Re: Block 2 & 2A PA – Council Letter 17/11/09

PLAN

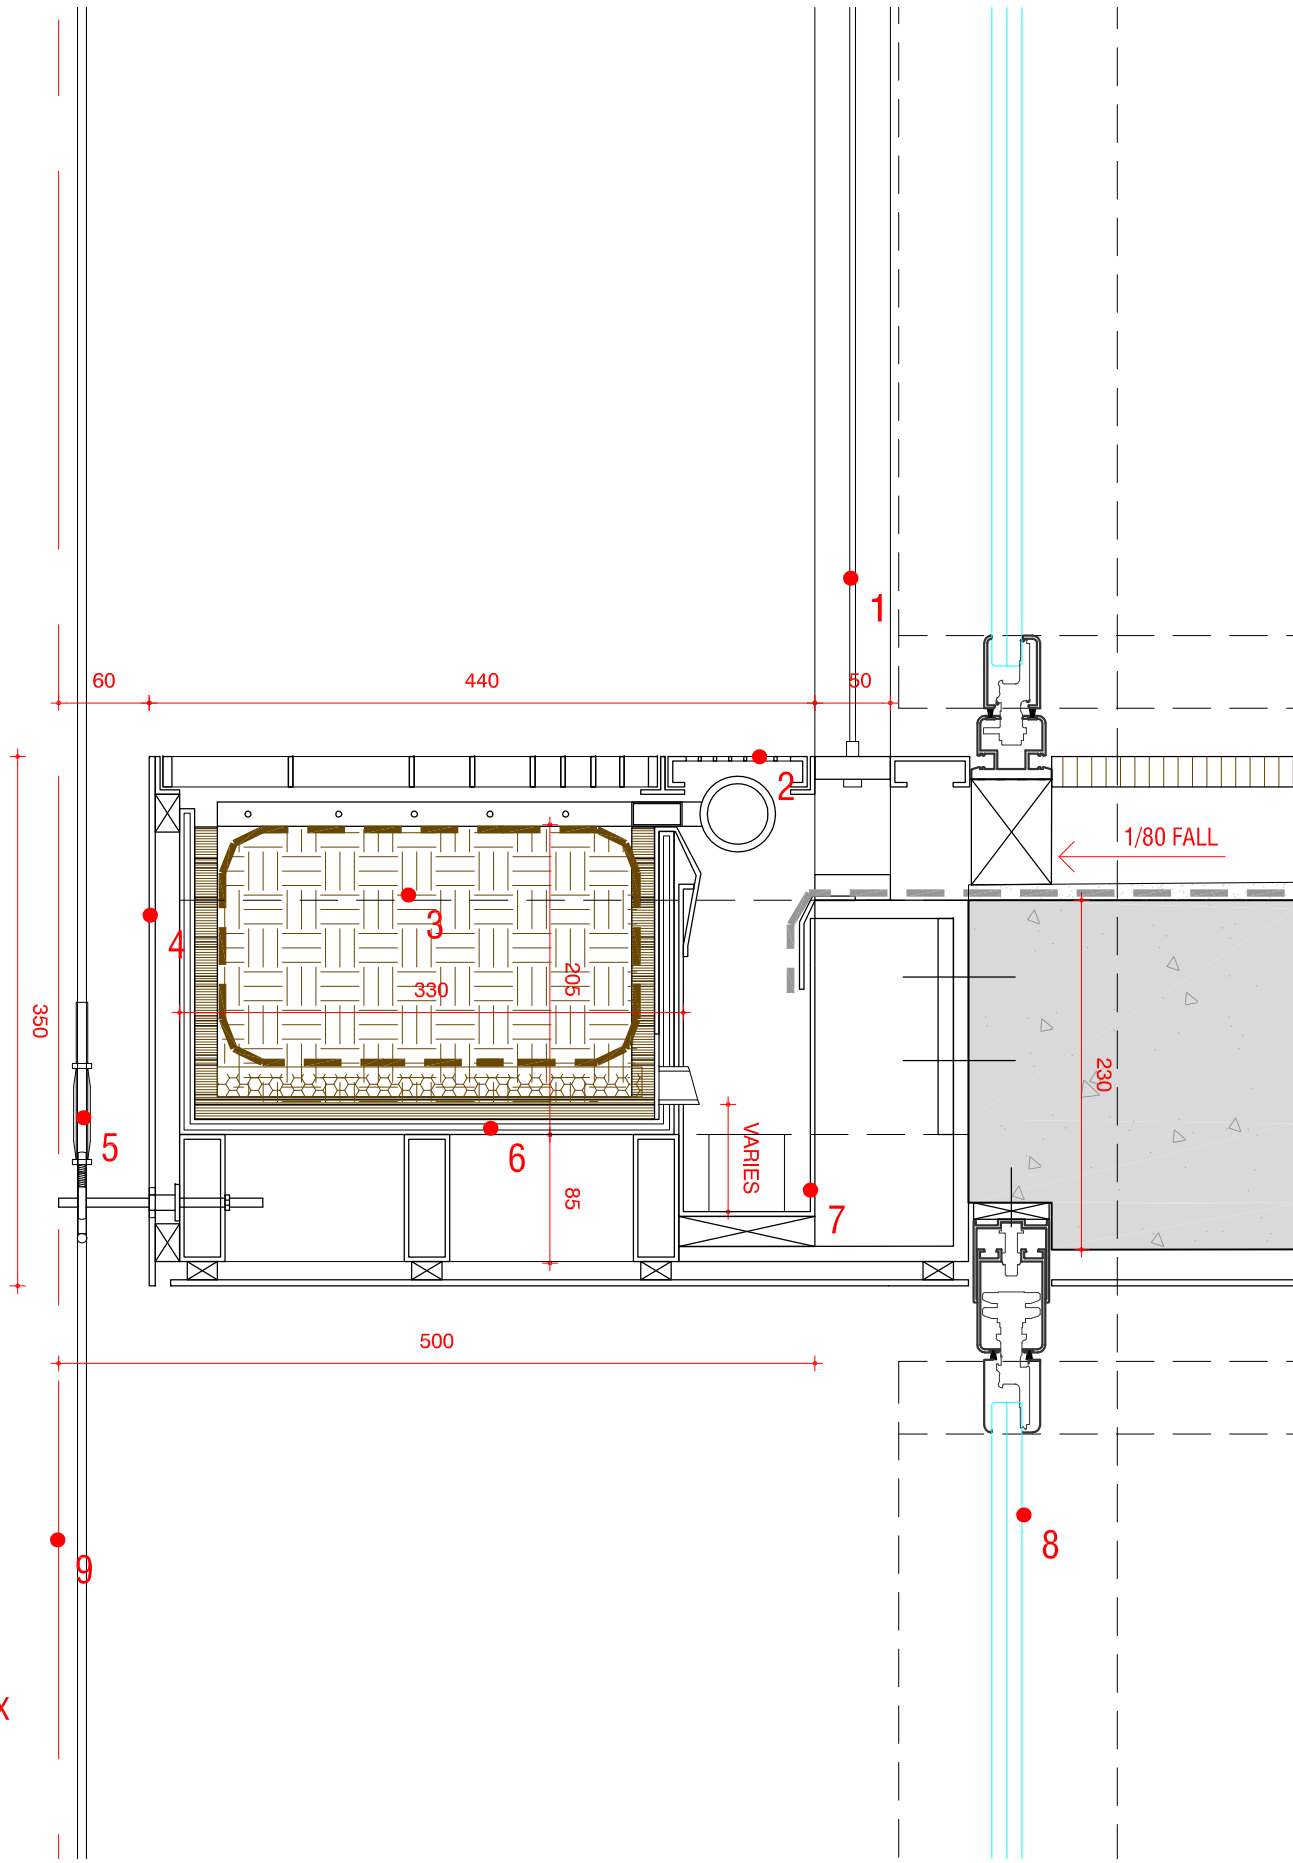
Area 2a terraces / connection to the Main Park			These issues are dealt with in the PPR
LANDSCAPE				
Pt1	Façade Planting	SCC		AJN have submitted images with the vines and planters stripped off. They have commented within the PPR regarding similar comments. Patrick Blanc's vegetal wall has been prototyped at Trio and the remaining work will be progressively prototyped with the display building. The PPR has commented on the maintenance costs.
SIGNAGE				
Pt1	Façade signage zones	SCC	Separate Signage DA	Arch/Client To suit base building construction provisions.
Pt2	Childcare Location and Details	SCC		This is responded to in the body of the PPR.

The modular planter system

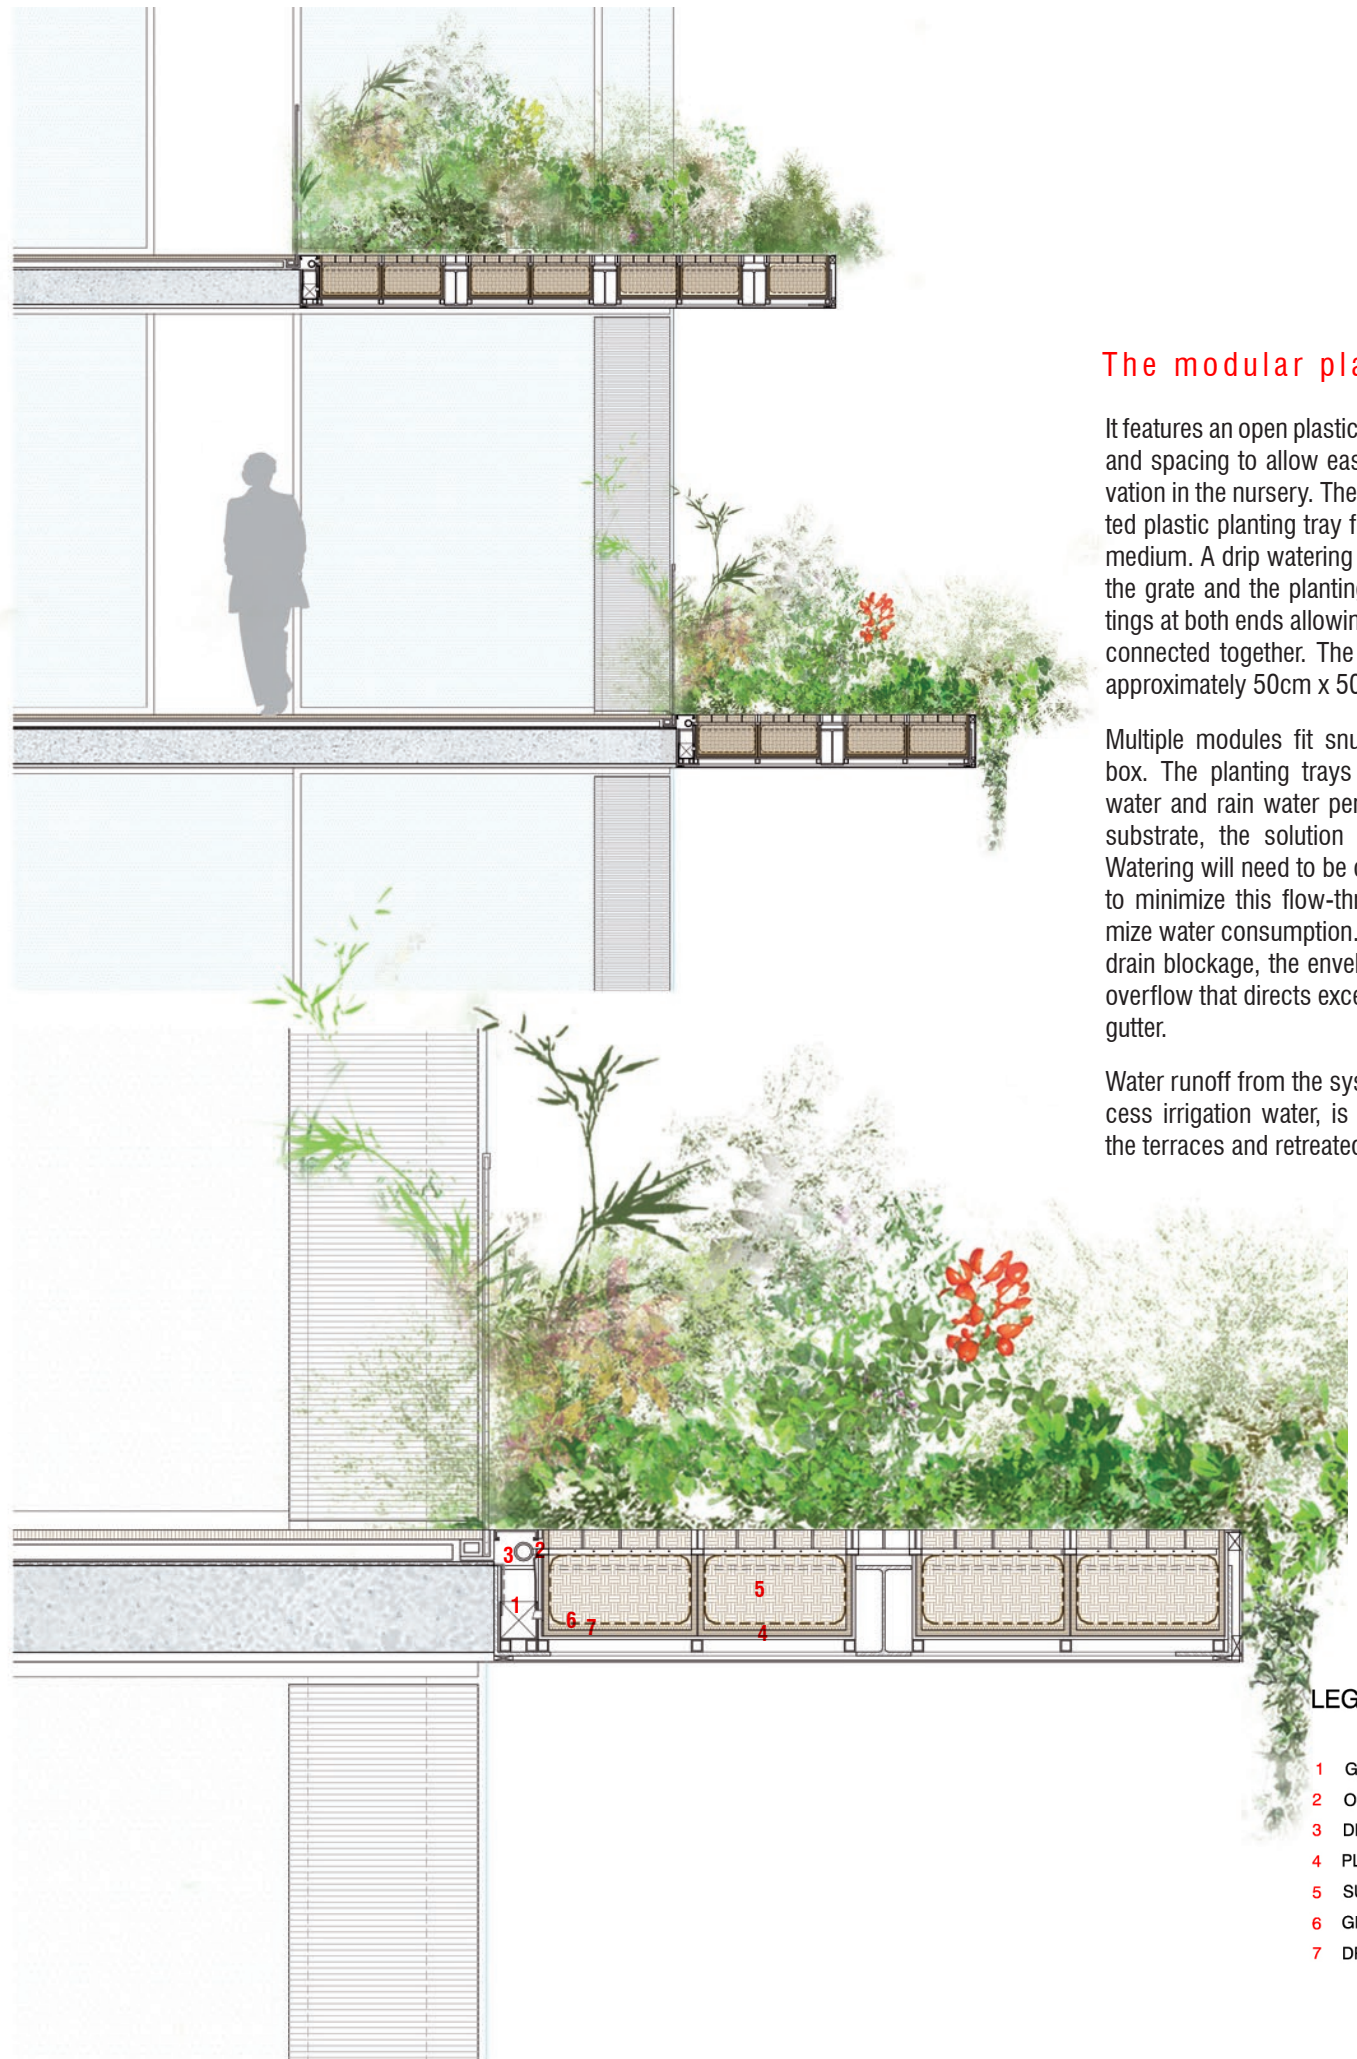
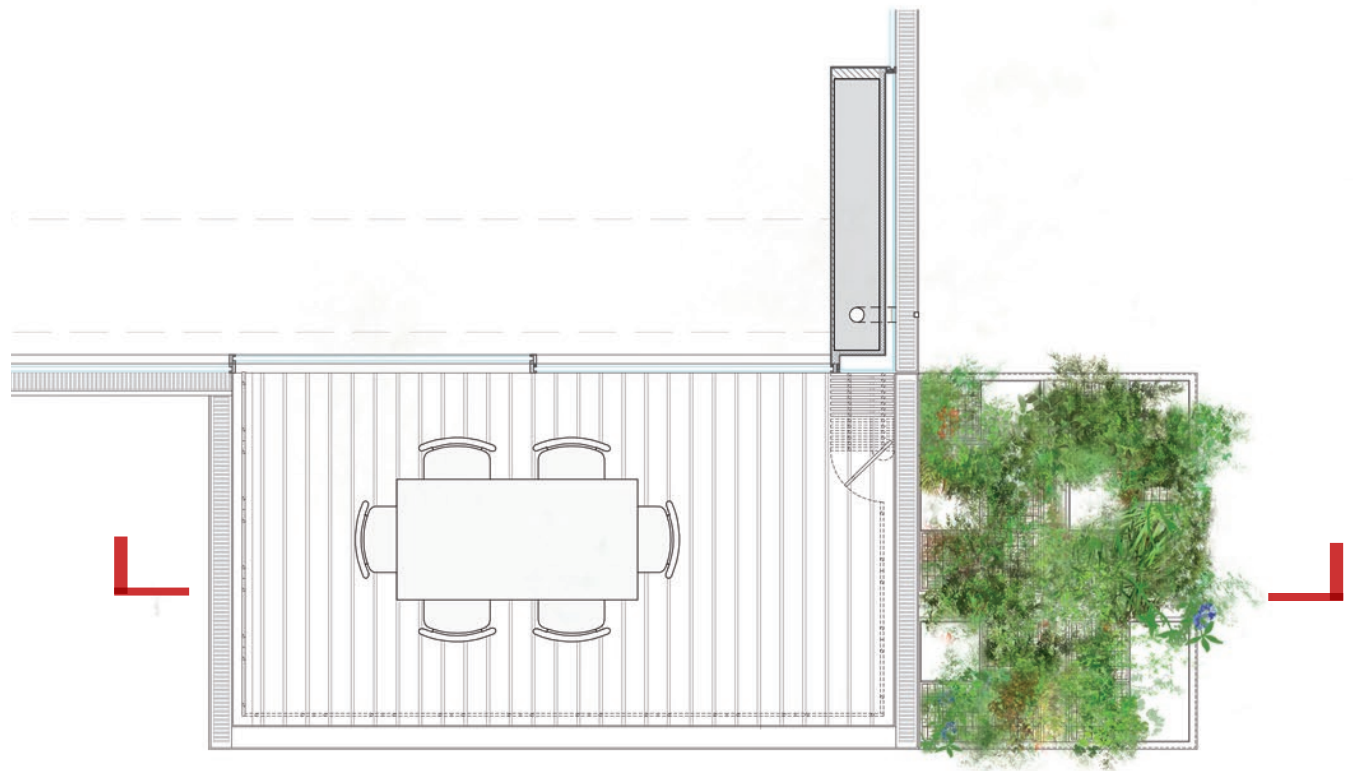
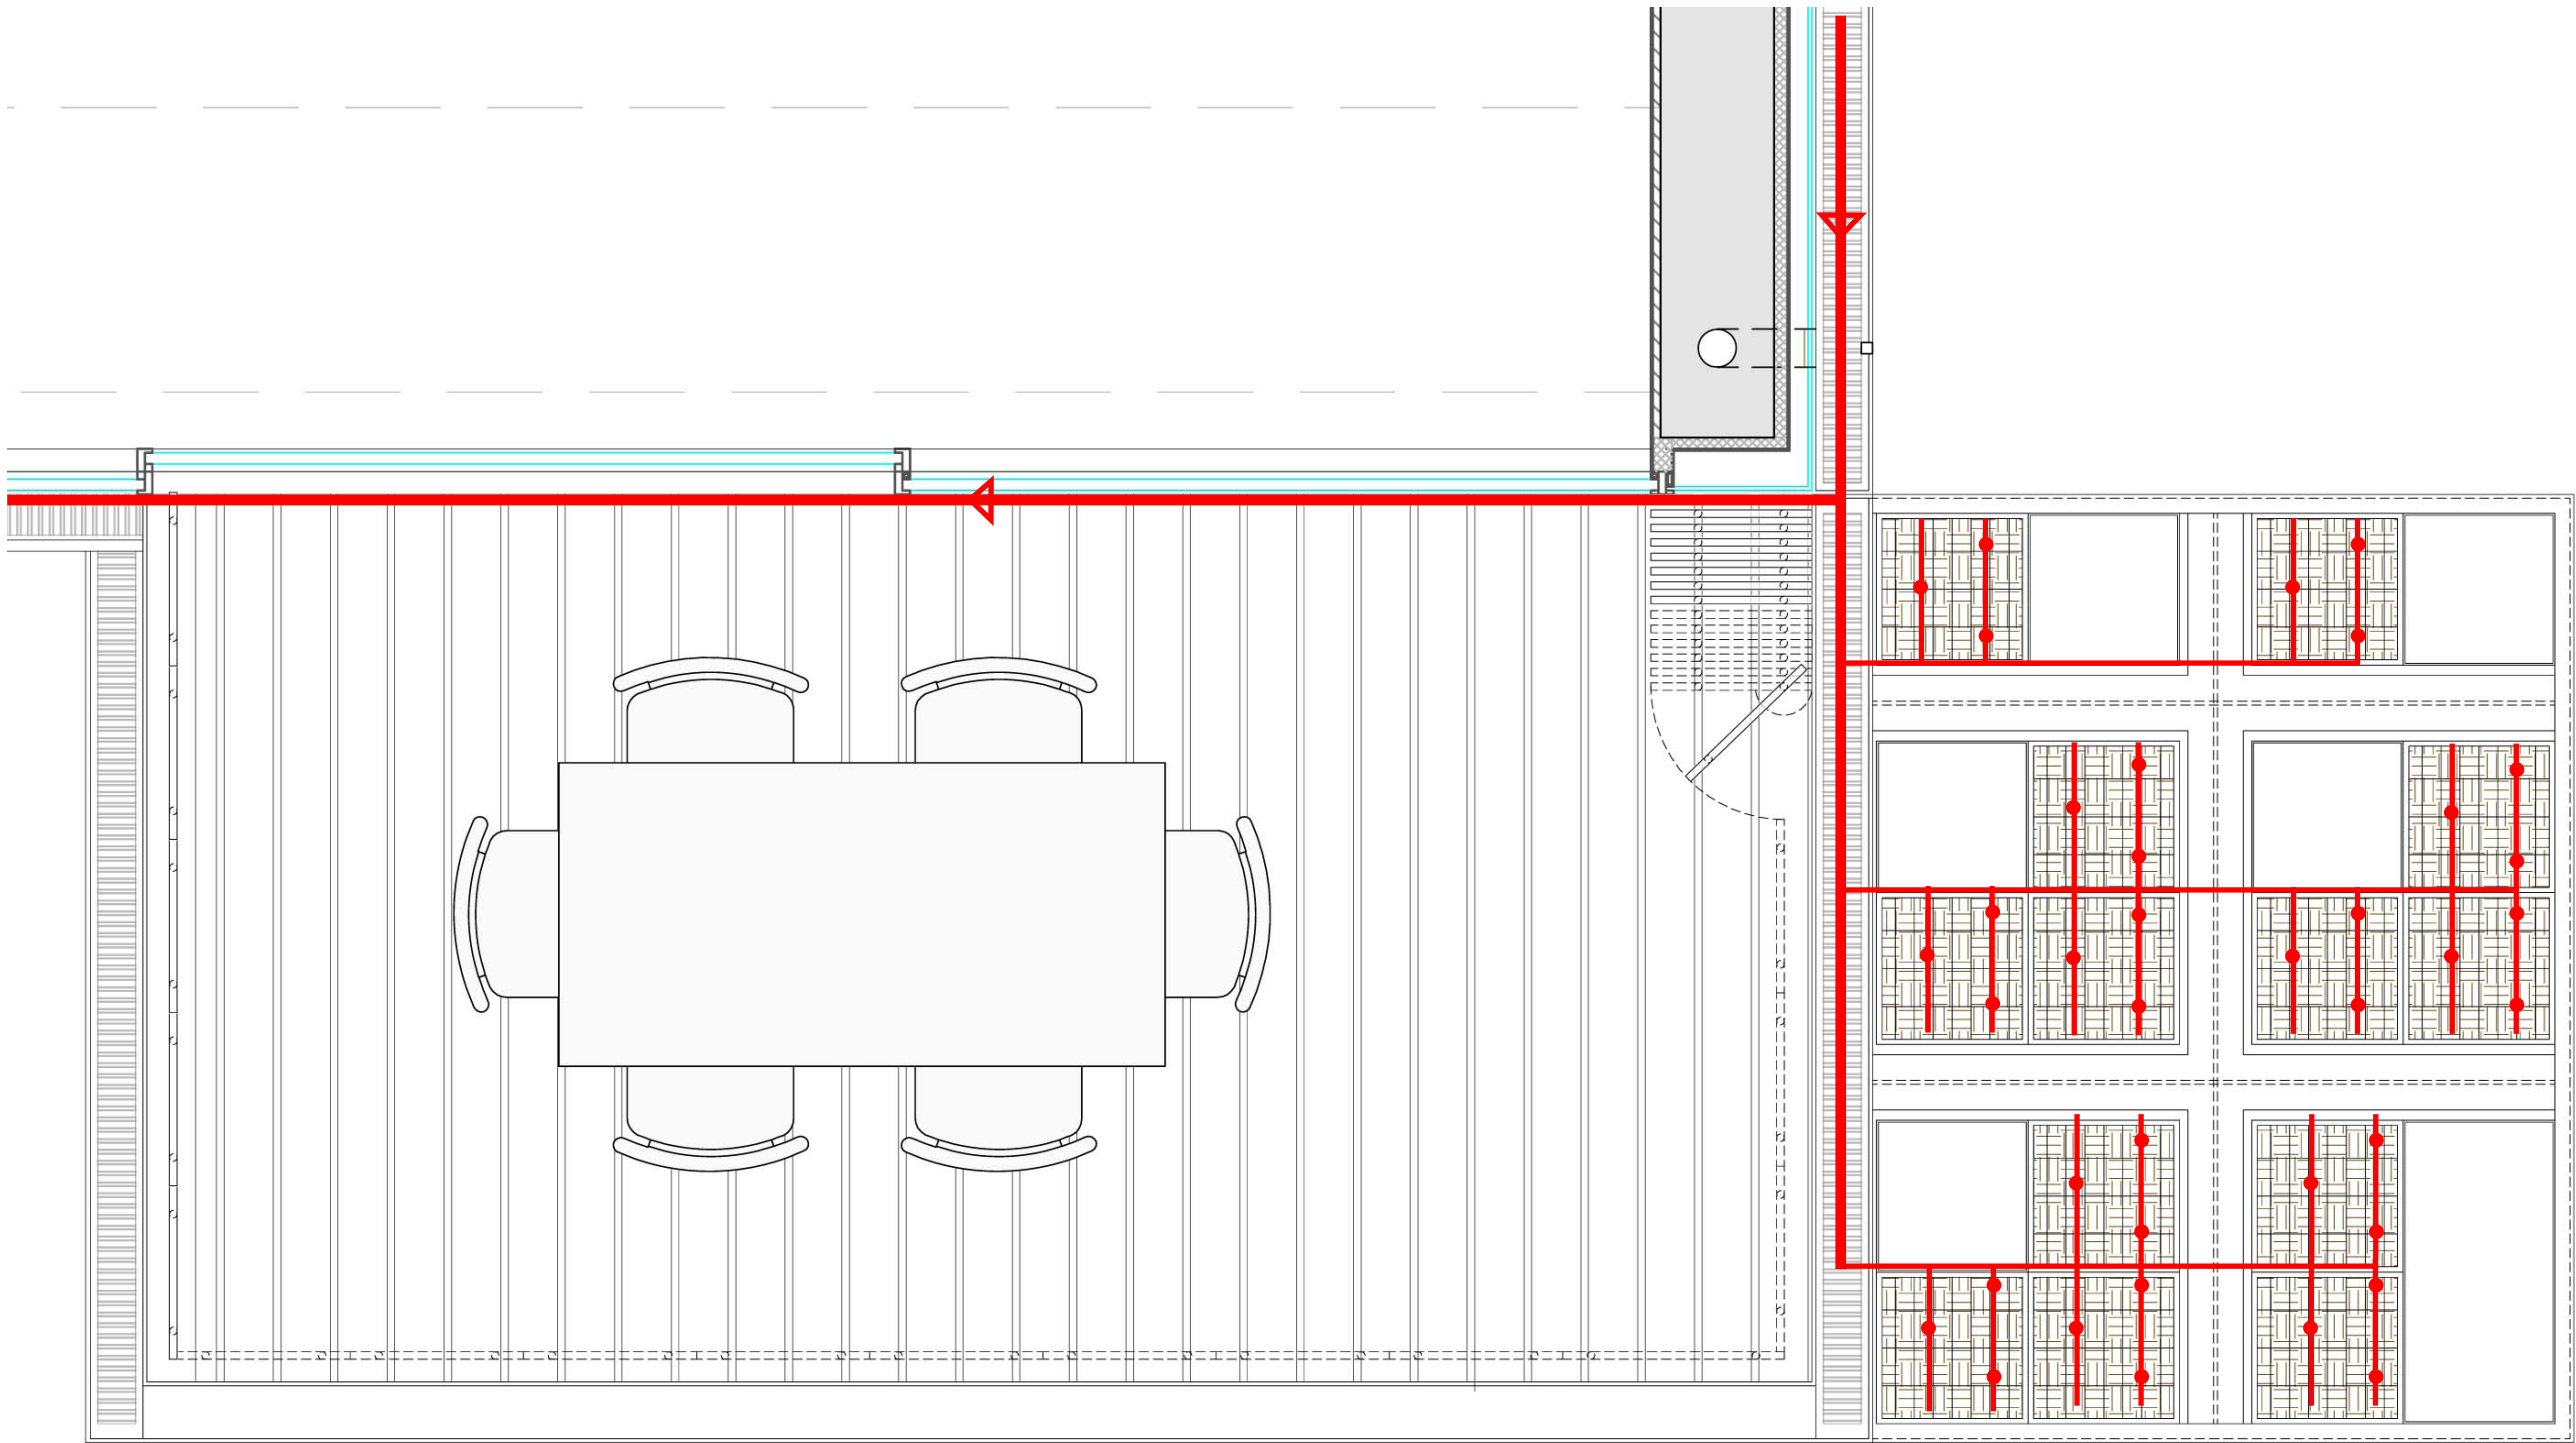
9	Landscaping of the Site (Both Public and Private)			<p>Frasers do not accept the full context of Council's submission. Items (a) and (b) are acceptable in the traditional sense. All work to the vegetal walls by Patrick Blanc and within planters affixed to the building will be certified by a suitably qualified person. All landscaping for a particular component will be complete prior to Occupation Certificate being issued. (Note: it is intended to have a staged completion of this building – podium, west tower, and east tower)</p> <p>Note there is no (c) listed</p> <p>With respect to (b) above and where applicable item (g) will be addressed.</p>
10	Modular Planting Systems			<p>Frasers will design , document and have such works structurally certified for the installation of these works which will be submitted to Council prior to CC. Council should not have to approve prior to CC for the above ground works. It is agreed that such will incorporate a maintenance regime for the built items.</p>
